From: Simon Davis
Sent: 21 April 2021 10:51

Subject: Y/152/20/RES - ADC Comments

Simon J Davis MRTPI
Principal Planning Officer
Directorate of Place

CLIENT:	Bilsham Road Development LLP	PROJECT:	Bilsham Road Yapton
SCALE:	1:100 (A1 ORIGINAL)	DRAWING:	C3H5 & C2H3 - Terrace Full Plans & Elevations
DRAWN:	RDB/SA	19284	P125
DATE:	01/09/20	—	—

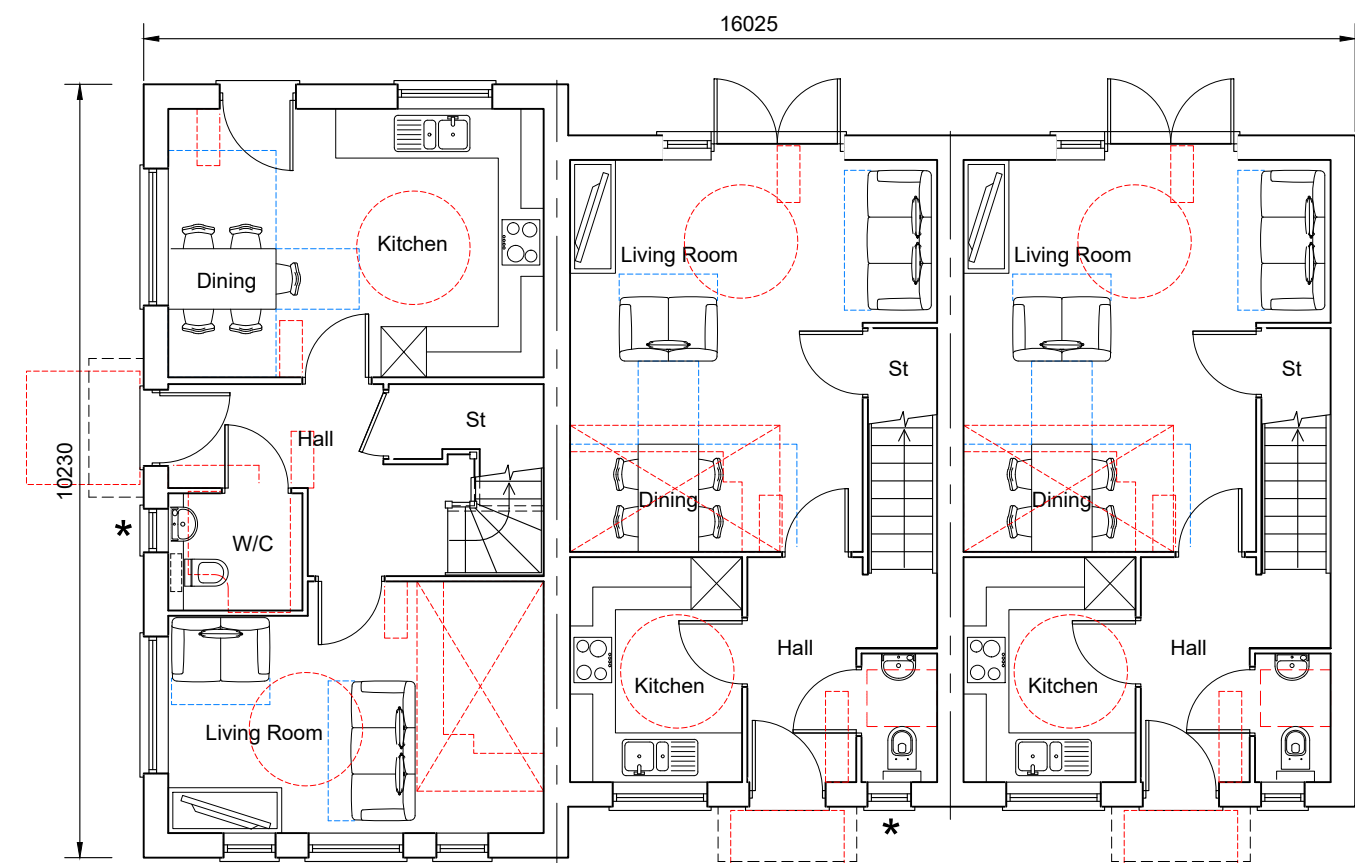
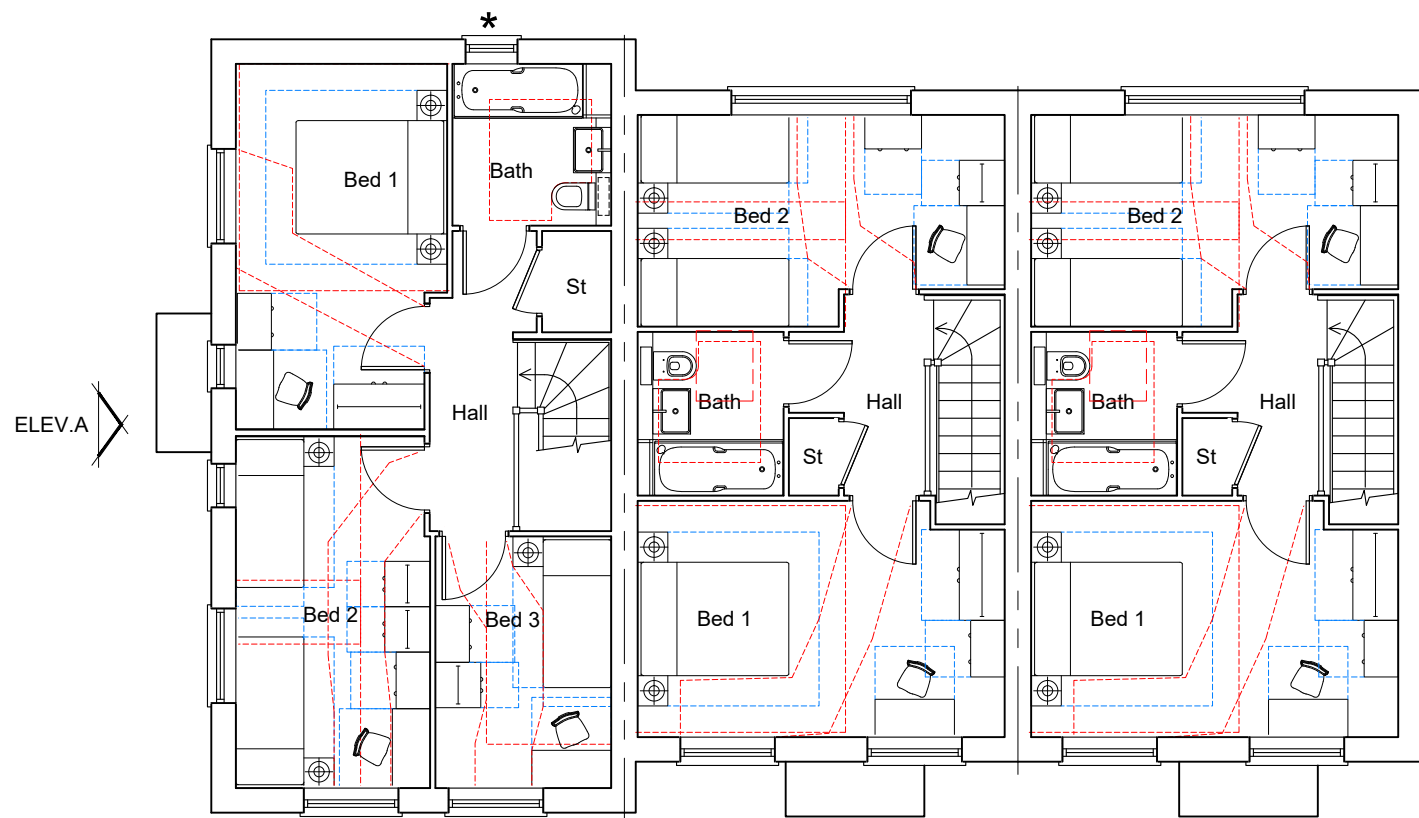
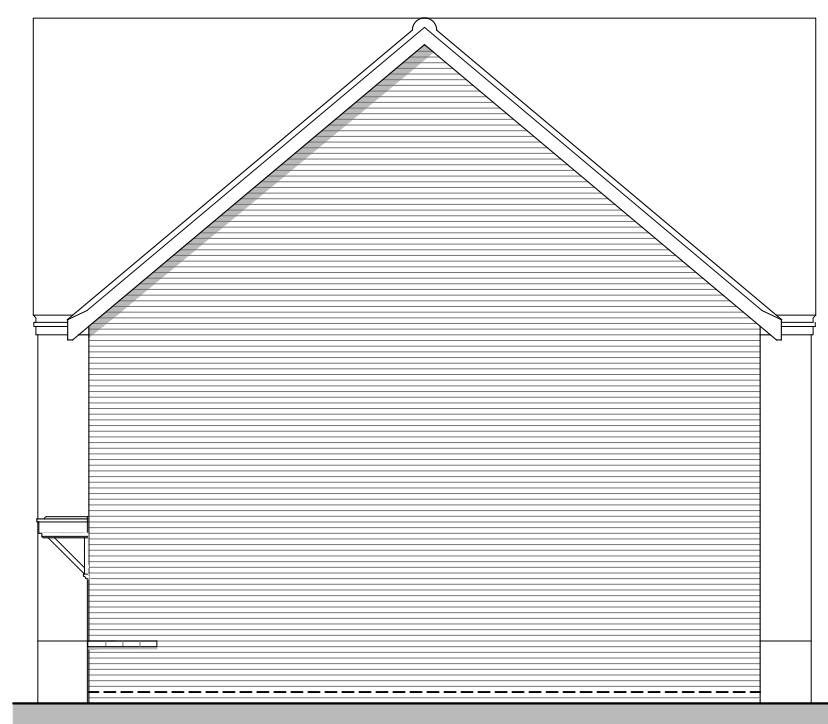
- These plots are between 10 and 10.5m – 13, 23, 28, 30, 91, 92, 93, 107, 108, 110, 118, 122, 139, 140, 144, 145, 148, 149, 150, 174, 177, 179, 217, 229, 233, 234
- These plots are less than 10m – 29 (8.7m avg*), 61 (9.6m), 67 (9.3m), 85 (9.5m), 90 (9m avg), 121 (9.2m avg), 123 (9m), 124 (9m avg), 138 (9m), 160 (9.2m), 226 (9.6m)

CLIENT:	Bilsham Road Development LLP	PROJECT:	Bilsham Road Yapton
SCALE:	1:100 (A1 ORIGINAL)	DRAWING:	C4H2 - Semi Full Plans & Elevations
DRAWN:	GE	19284	P128
DATE:	01/09/20		—

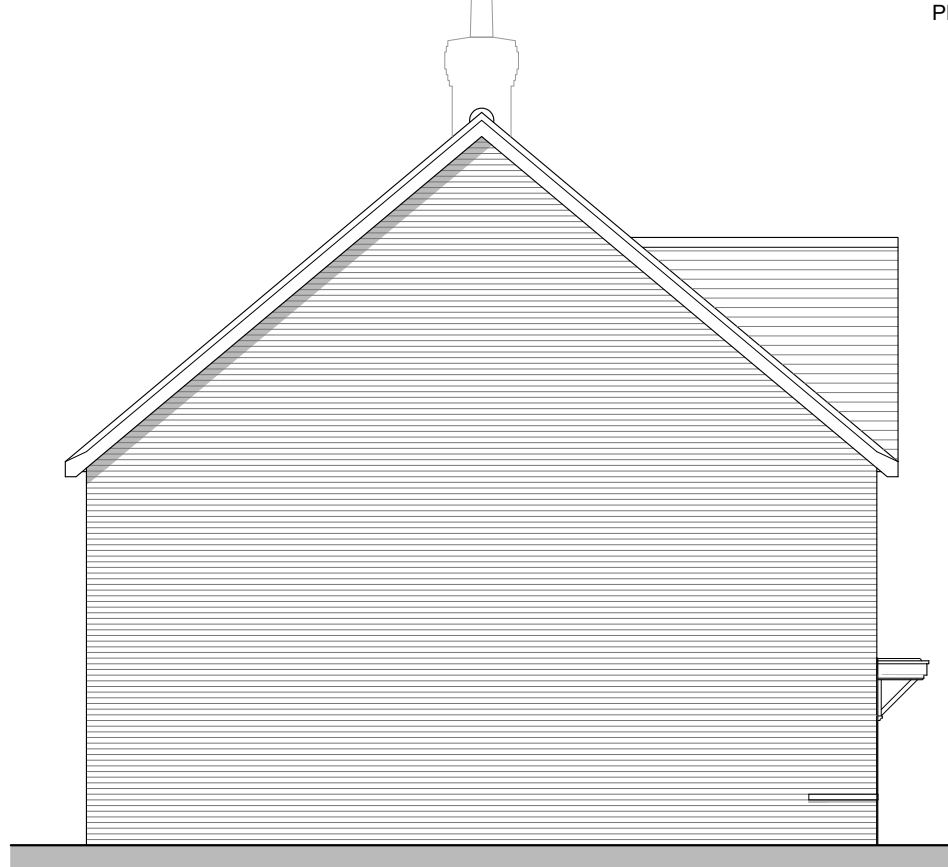
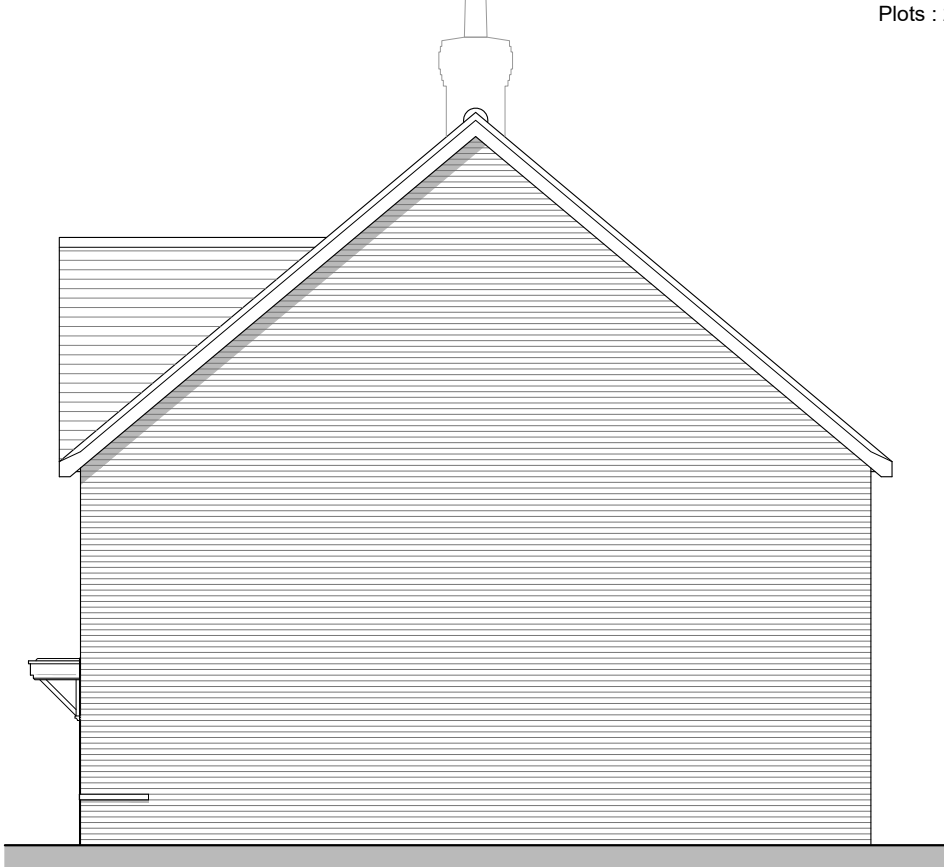
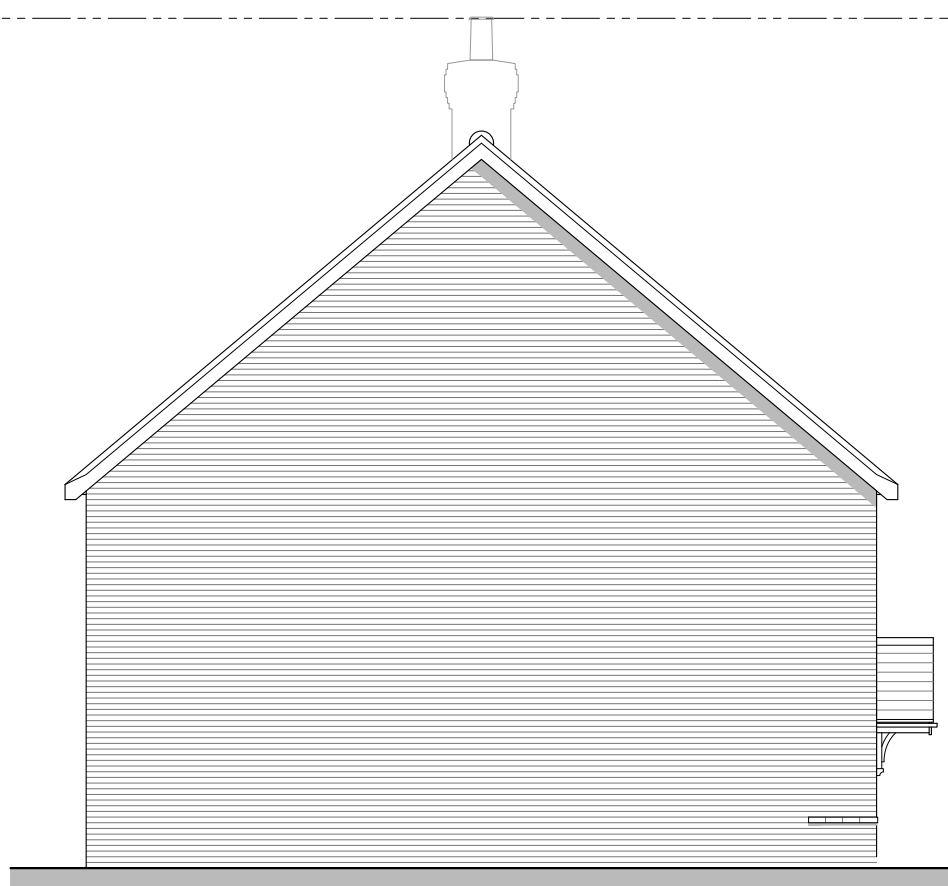
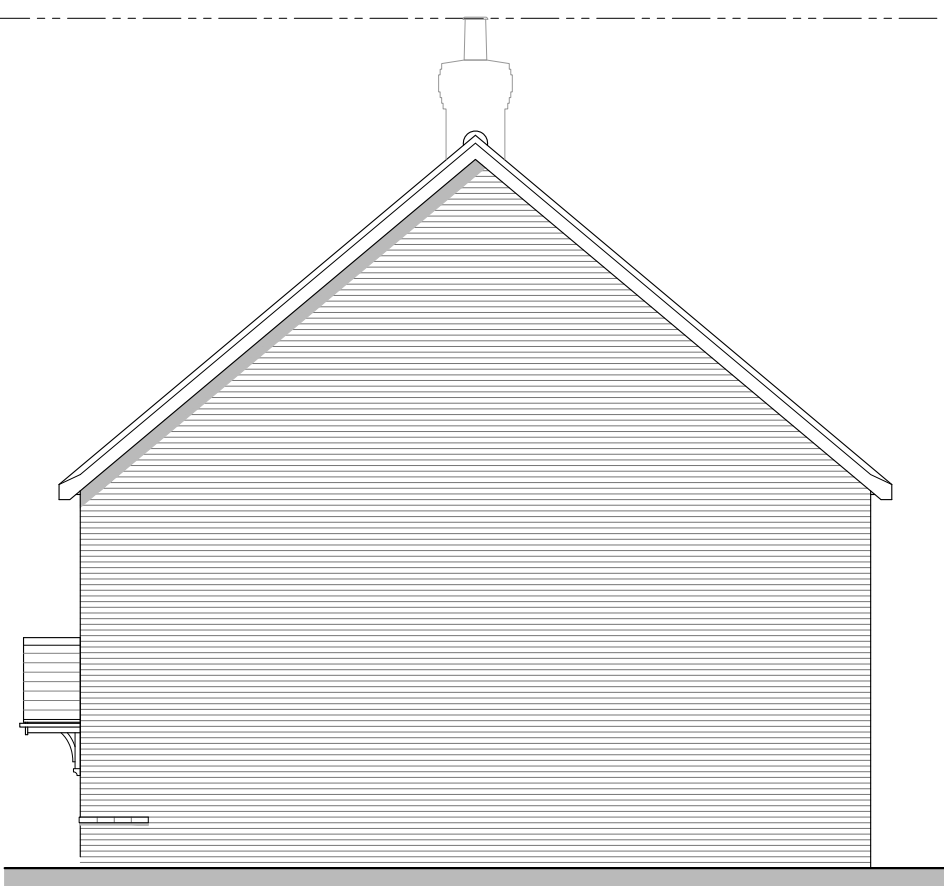
- 182-185 F to 177-179 F only 15m (1m shortfall)
- 206 F to 193 F only 14m (2m shortfall)
- 167/168 F to 172/173 F – 14m (2m shortfall)
- 171 S to 212/213 F – 12m (2m shortfall)
- 170 F to 214 S – 12m (2m shortfall)
- 162 S to 163/164 R – 12m (2m shortfall)
- 138 R to 150 R – 20m (1m shortfall)
- 140 R to 149 R – 20m (1m shortfall)

143 S to 144 R – 12m (2m shortfall)
113 R to 121 R – 19.5m (1.5m shortfall)
92 R to 94 S – 13m (1m shortfall)
26/27 F to 16/17 F – 14m (2m shortfall)

Front Elevation
Plots : 13 - 15

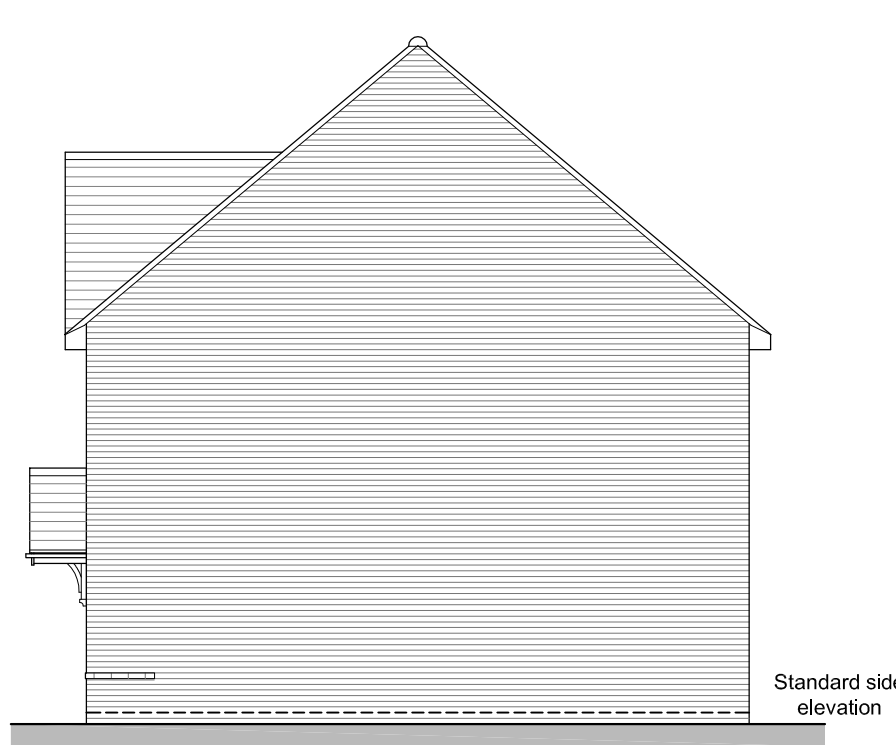
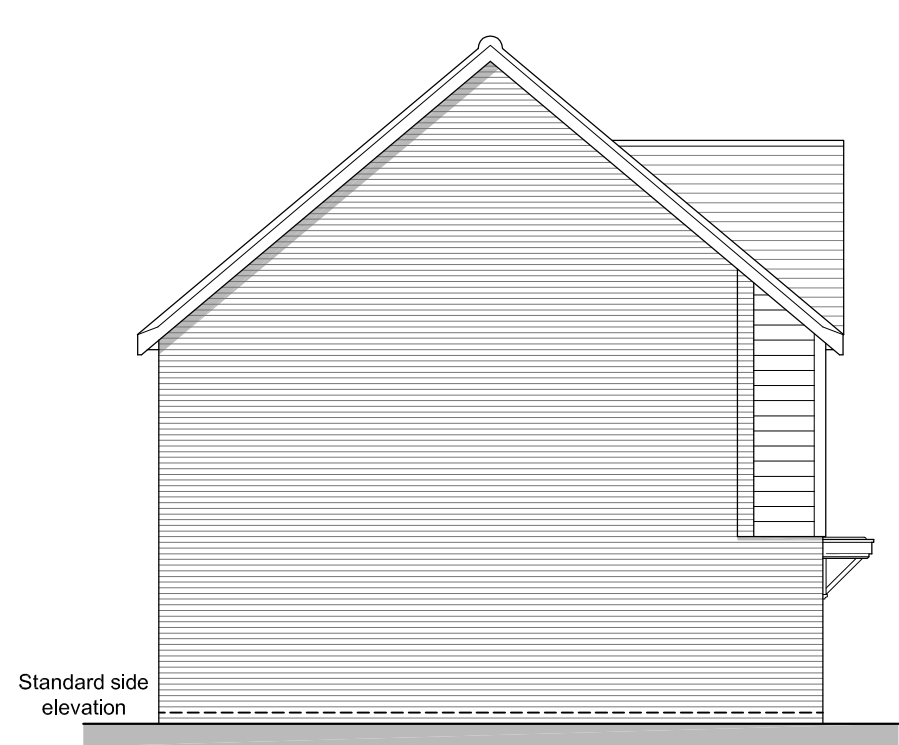
- (K) Also, plot 90 overlooks 87 & 88's rear garden at only between 3 and 8m.
- (L) I have concerns with the front outlook of plots 9-12 (flatted building) & 13-15 which essentially face a row of parking spaces & car ports. I consider that this area (streetscene) should be subject to greater landscaping to break up the hard surfacing.

CLIENT:	Bilsham Road Development LLP	PROJECT:	Land At Bilsham Road, Yapton
SCALE:	1:100 (A1 ORIGINAL)	DRAWING:	2B4P Type B - Semi Full Plans & Elevations
DRAWN:	RDB/GE	19284	P132
DATE:	Sep 2020		—

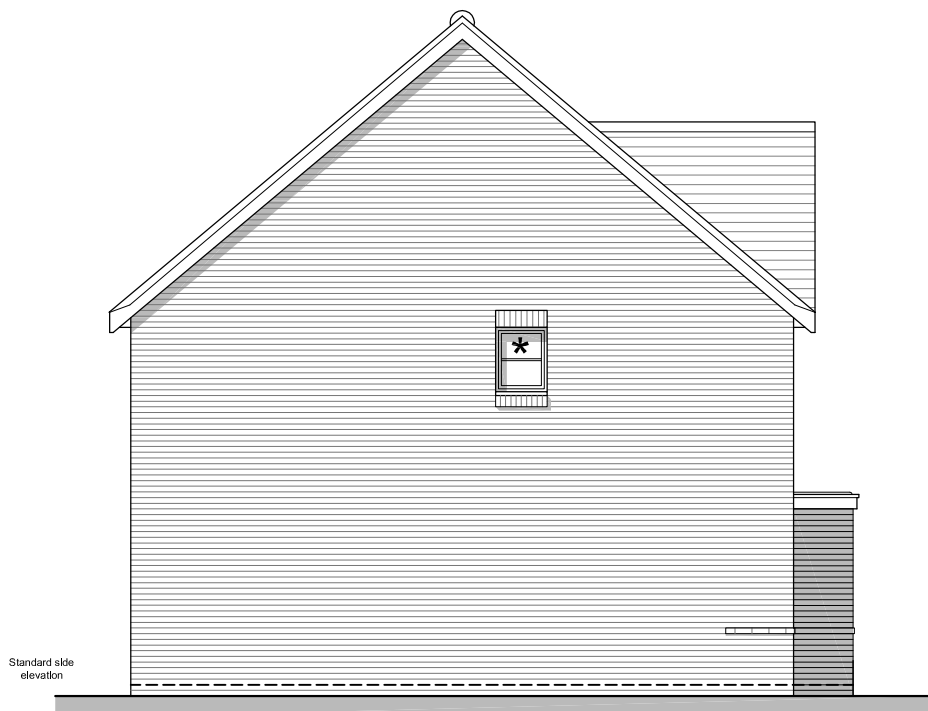
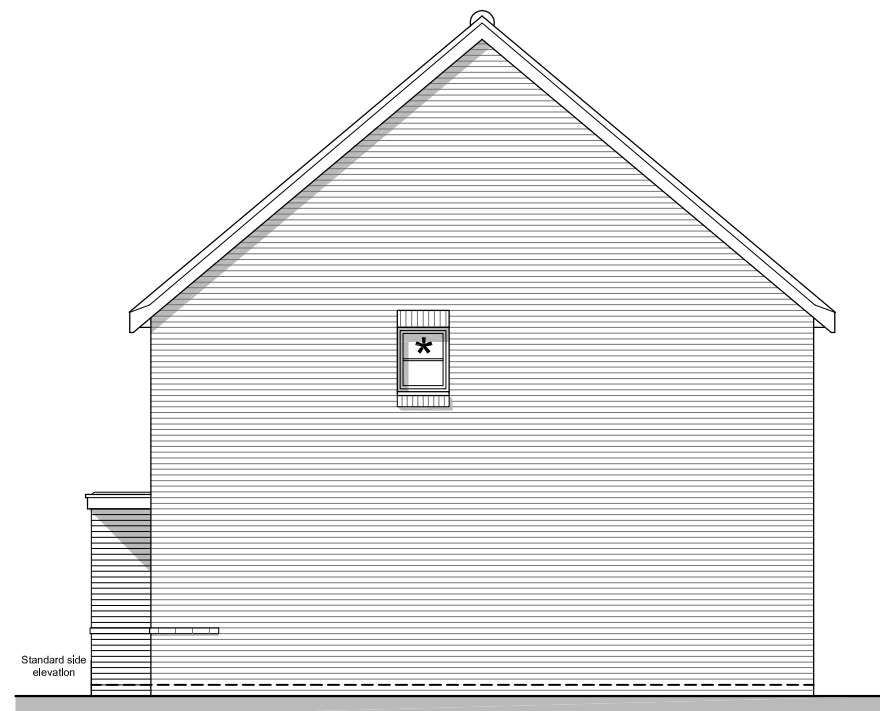
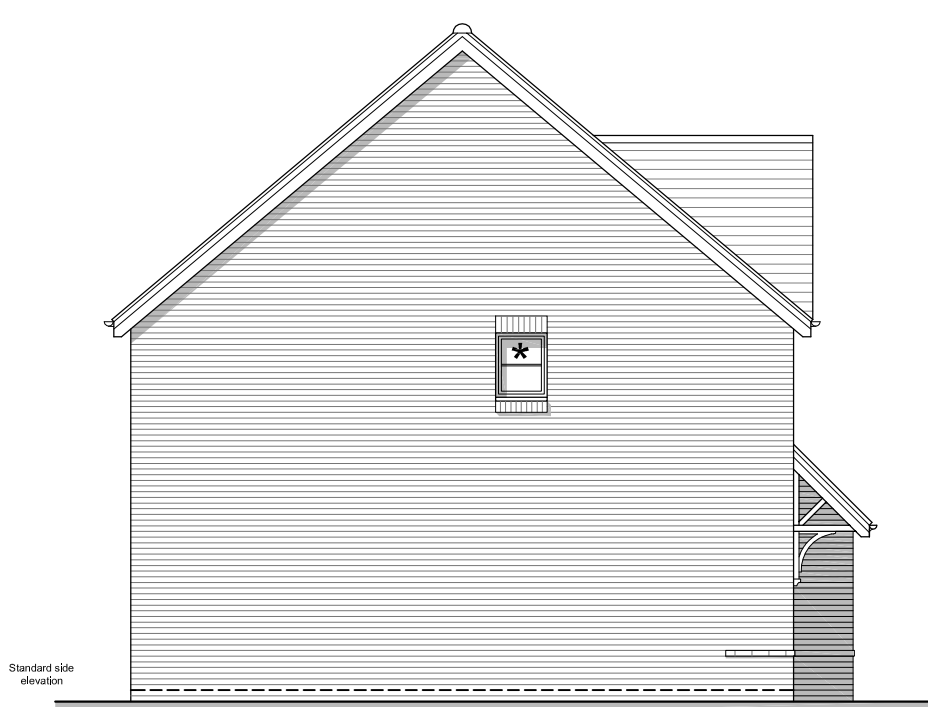
- (I) The interface distance between plot 192 to rear of 39 Tack Lee Road should be 21m but appears only 20-20.5m. I would rather this was at least 21m as it concerns an existing dwelling.
